GREYSTANES SOUTHERN EMPLOYMENT LANDS - MODIFICATION (MP 06_0181 MOD 1)

Thank you for the opportunity to provide comment on a proposed modification to the Minister's approval of the major project application for the Greystanes Southern Employment Lands (SEL).

Fairfield City Council has reviewed the modification and would like to provide the following comments:

Figure 11: Stormwater Management Strategy (quarry site)

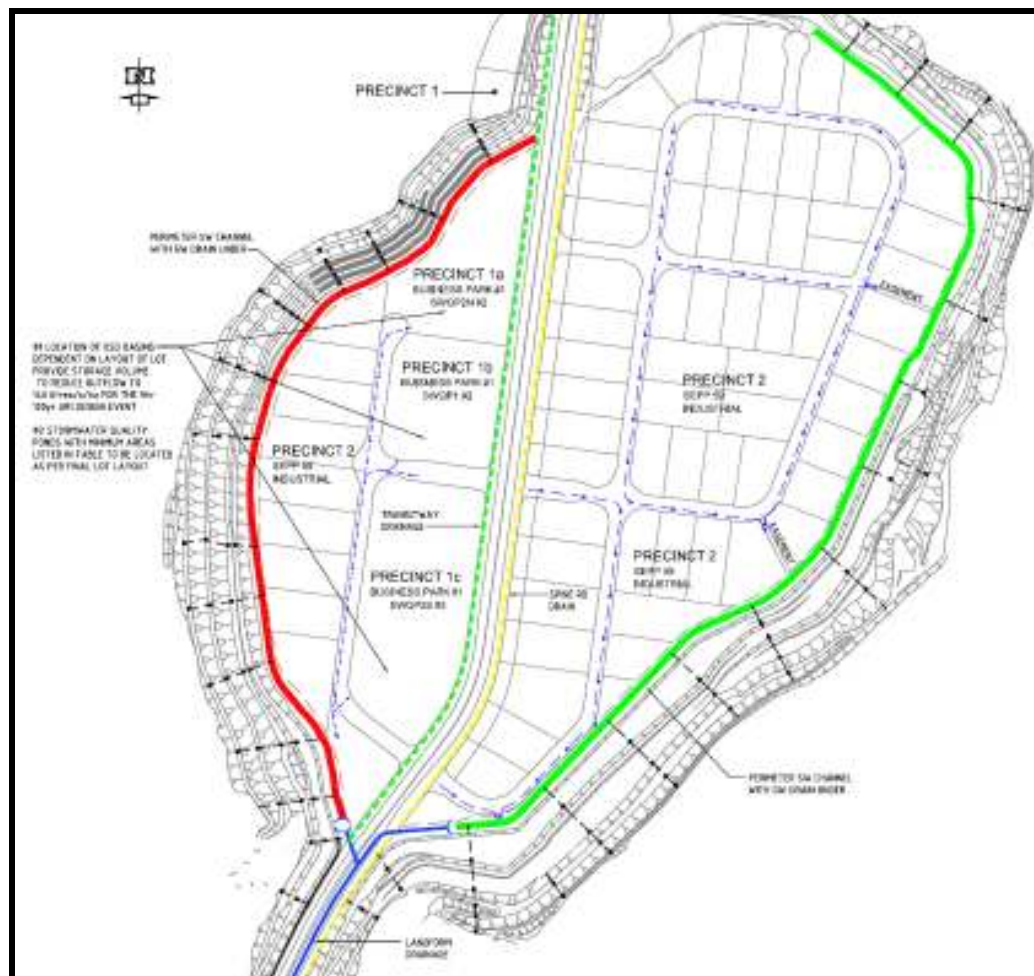
While a plan of the proposed detention basin has been provided and indicates all the inlet details, there is no detail on the outflow pipes or spillways. Details on the inflow and outflow hydrographs of this detention basin have also not been provided. Council has previously requested details of the connection to Prospect Creek, and details of any erosion control measures that might be implemented to minimise the impact on the creek. The connection details are important for Fairfield City Council to assess the erosive impact of this discharge to Prospect Creek.

- Details of the connection of the detention basin to Prospect Creek be provided to Council to ensure erosion impacts on the Creek are minimised. Information on the

outflow pipes or spillways from the detention basin and the inflow/ outflow hydrographs of the basin to be provided.
